From: Rhiannon Lloyd
Sent: 11 May 2026 15:19
To: Planning.Responses
Subject: Fw: Re: FP/31/26/HH - 9 Roundle Square
Attachments: 9, Roundle Square Planning Amendment Sheet 5a of 6 .pdf; 9, Roundle Square Planning Amendment Sheet 6a of 6 .pdf

From: BRYAN BUTCHER [REDACTED]
Sent: Monday, May 11, 2026 14:08
To: Rhiannon Lloyd <Rhiannon.Lloyd@arun.gov.uk>
Subject: Re: Re: FP/31/26/HH - 9 Roundle Square

Sheet 5 a of 6

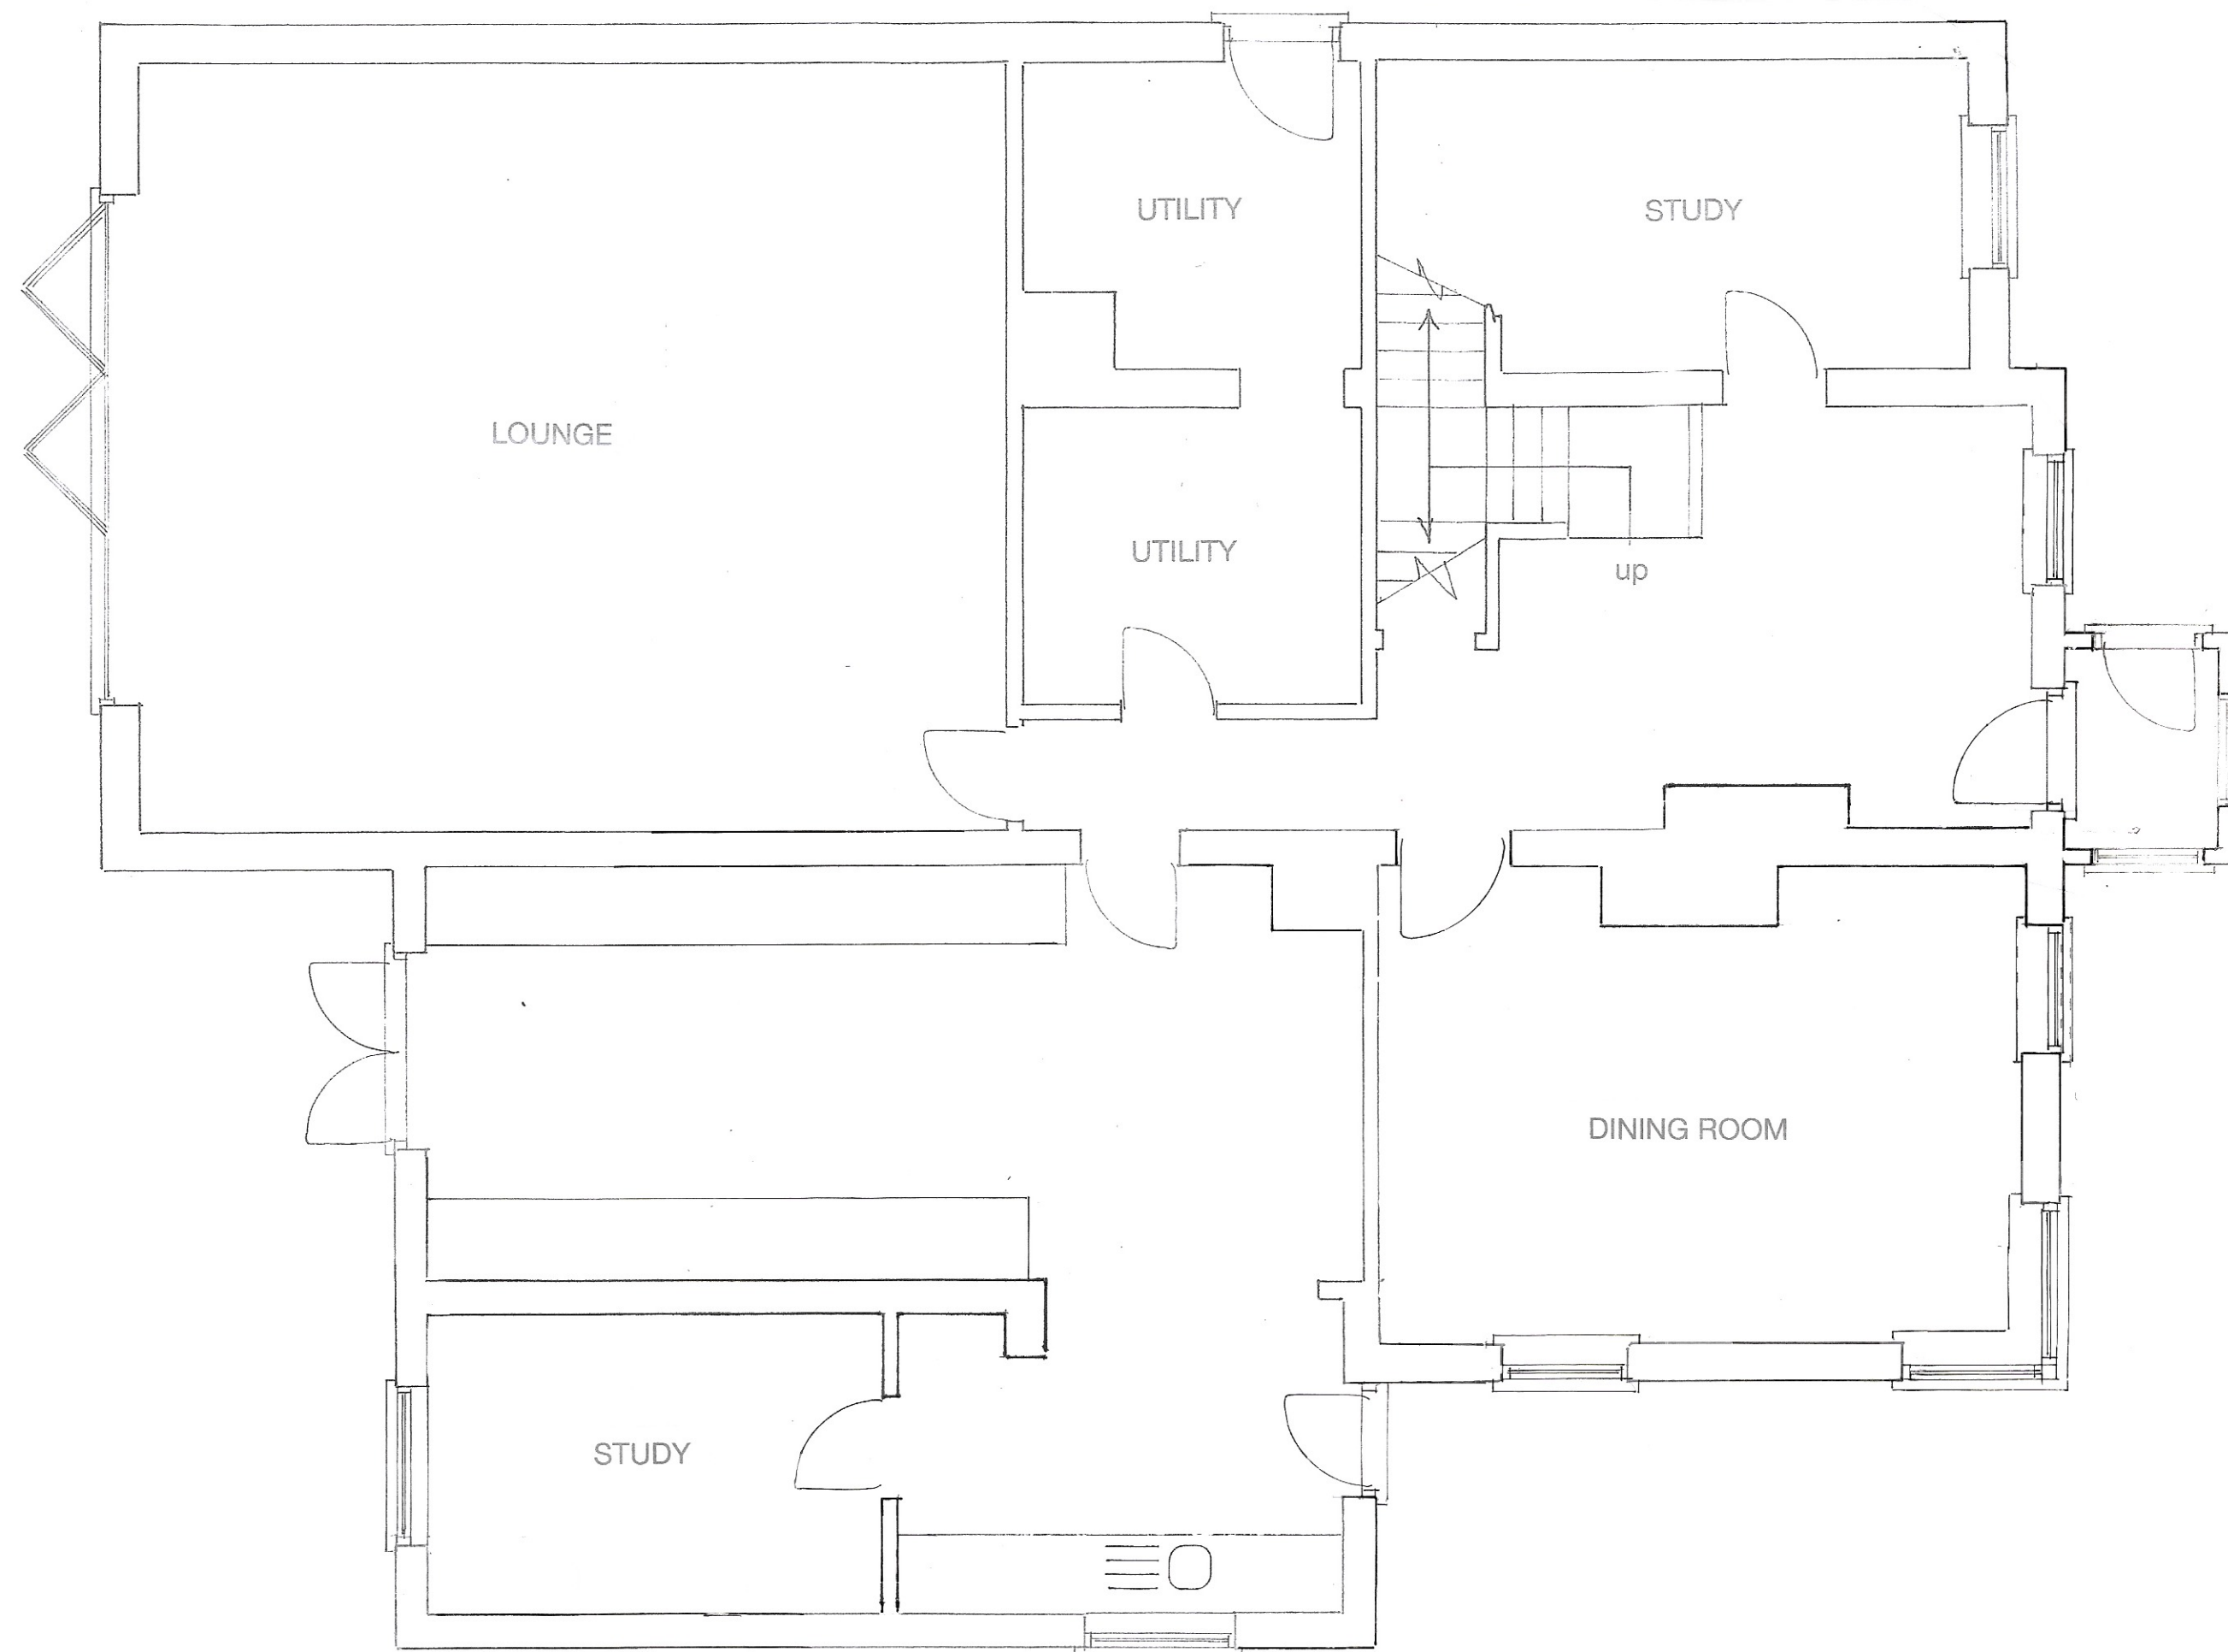
I also notice that the existing plans appear to be incorrect. The floor plans, elevations and roof plan do not show the single storey porch as existing. The roof plan does not accurately show the existing crown roof either.

Please could the plans be updated to accurately reflect the existing situation.

I am pleased to attach amended plans.

Sheet 1 of 5

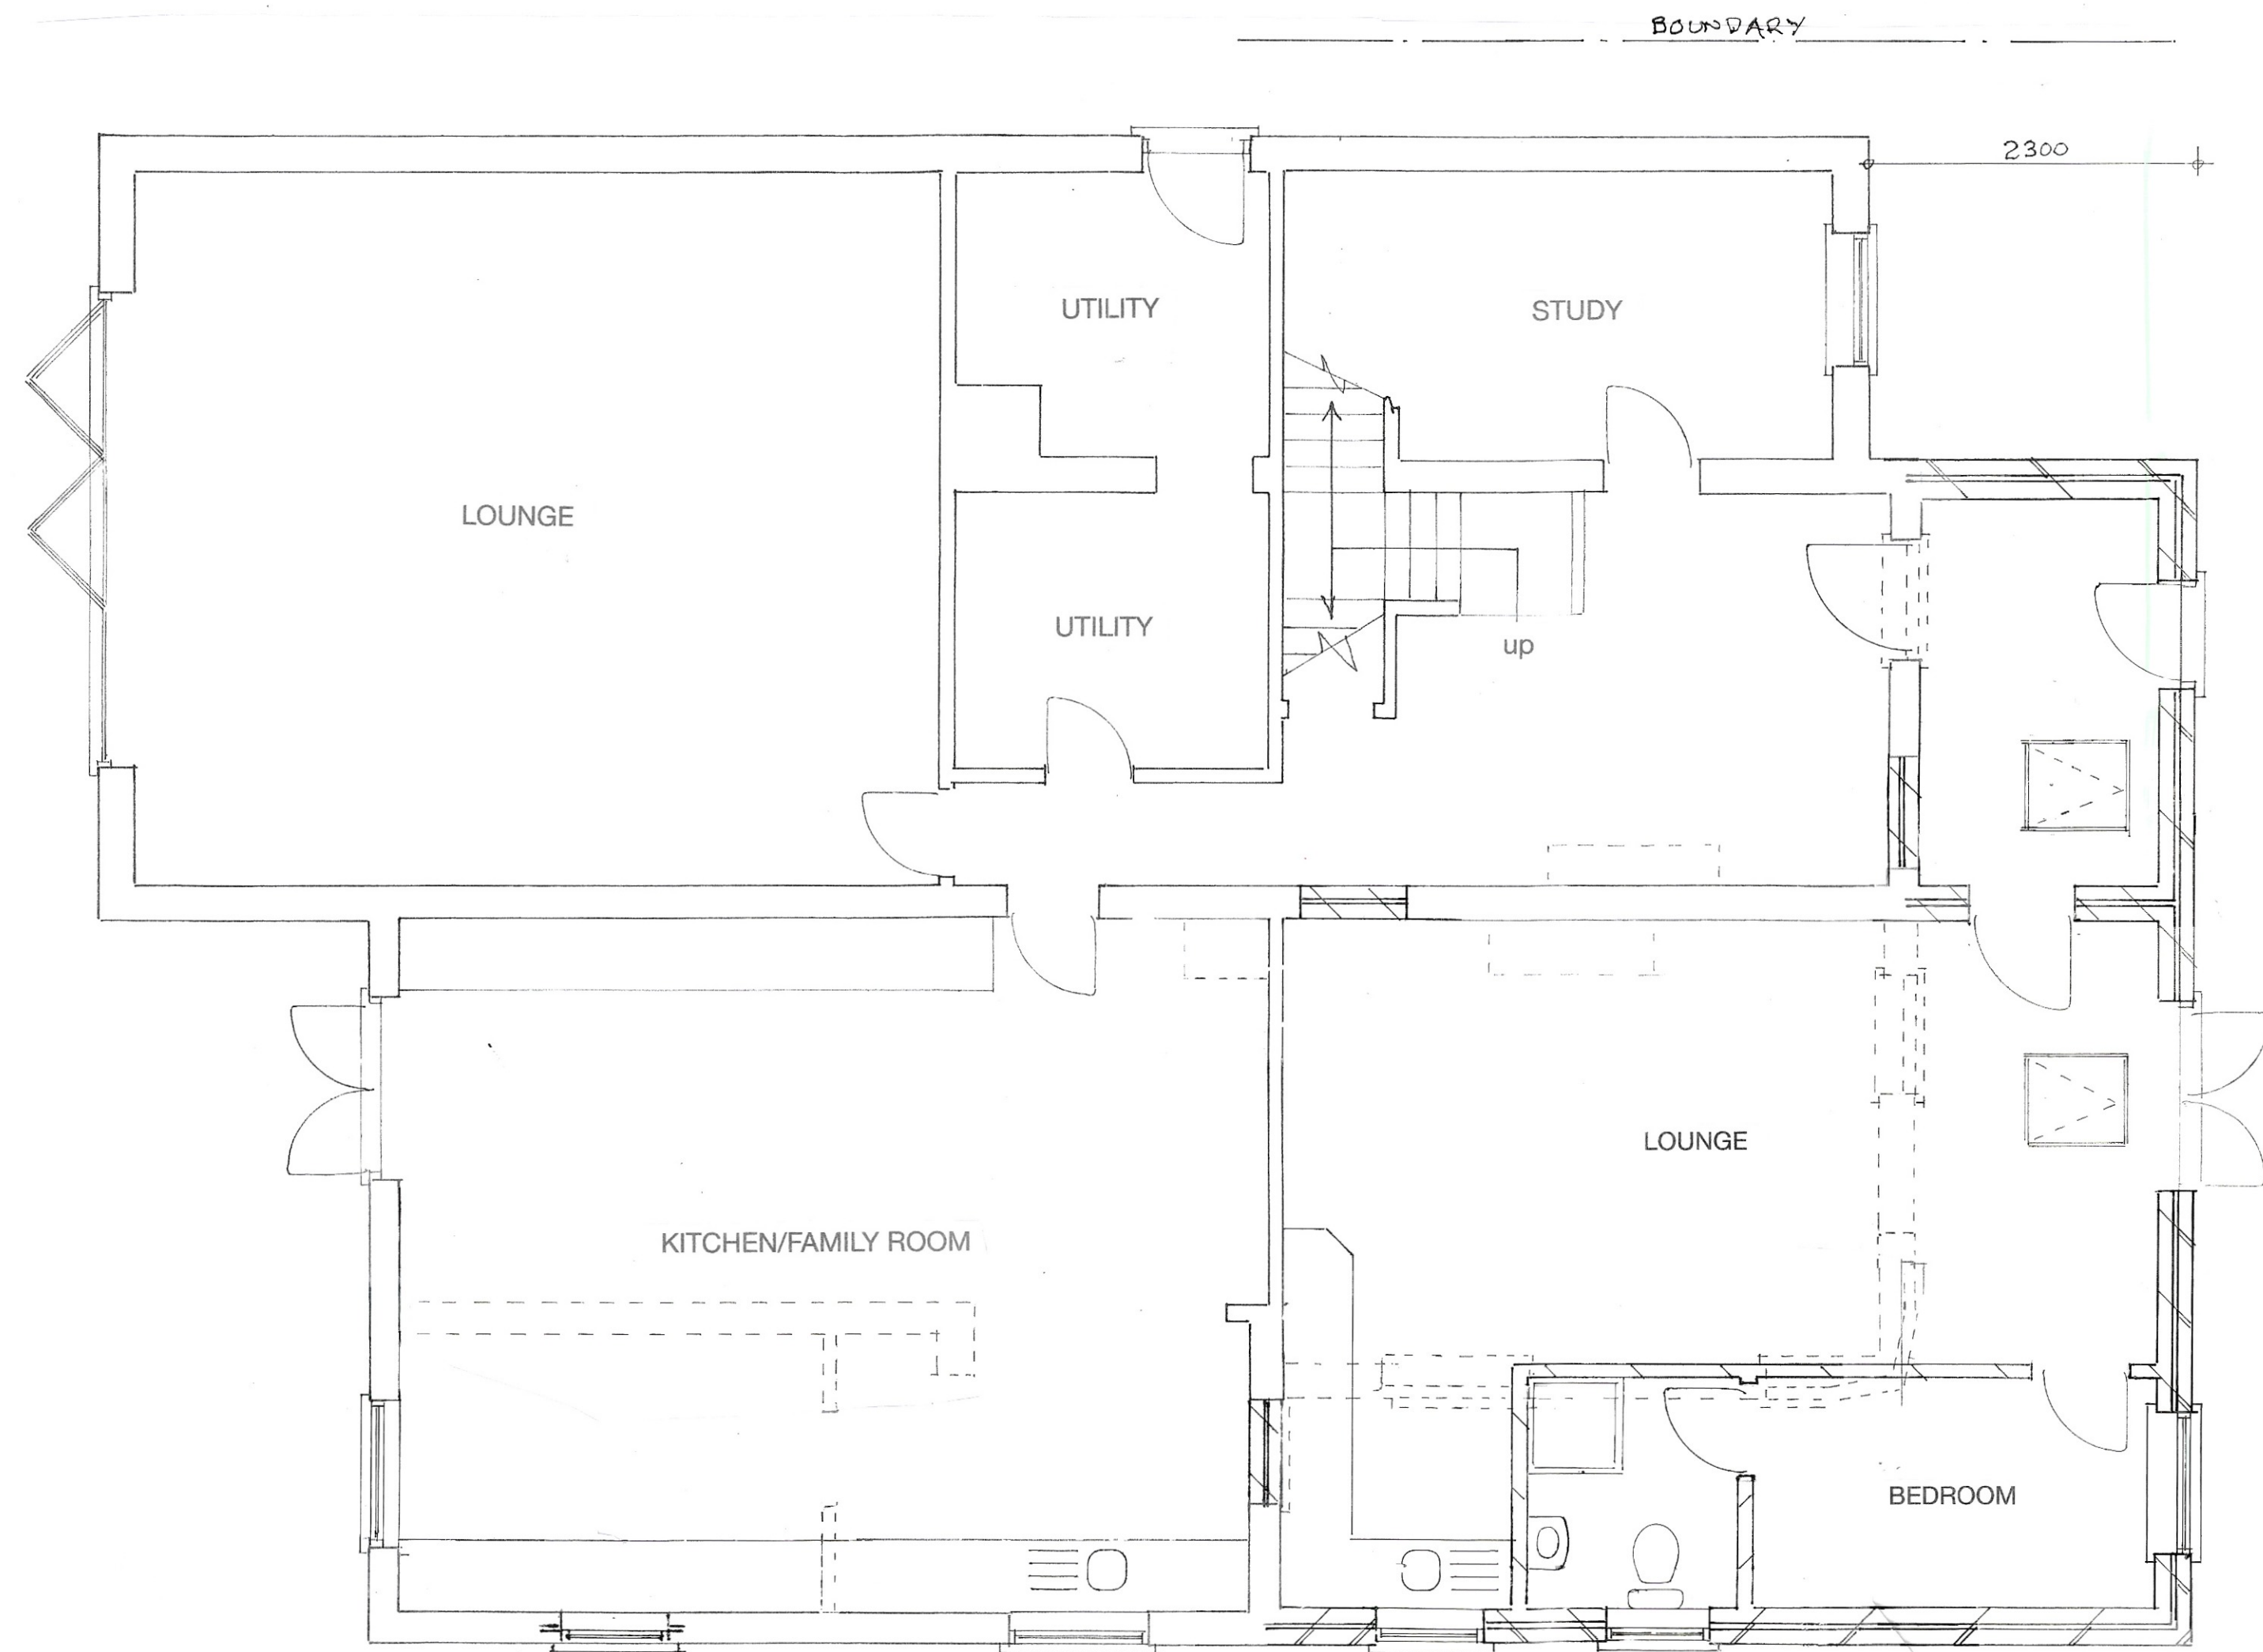
Following assessment, I am writing to seek an amendment to the front (east) elevation. The plans show two doors within this principal elevation; however, it would be preferable to have just one door within this elevation. This is to reflect a more simple and coherent principal elevation, in character with the rest of the street scene.

Please provide amended proposed ground floor plans and proposed elevations to reflect this change.

I would also appreciate clarification regarding the proposed ground floor, as the plans appear to show two separate kitchen areas. Could you please confirm whether this is correct?

The duplication of rooms including one large kitchen/family room and smaller kitchen reflects that Mr Watt's Mum, who has just lost her husband is to move in with the family.
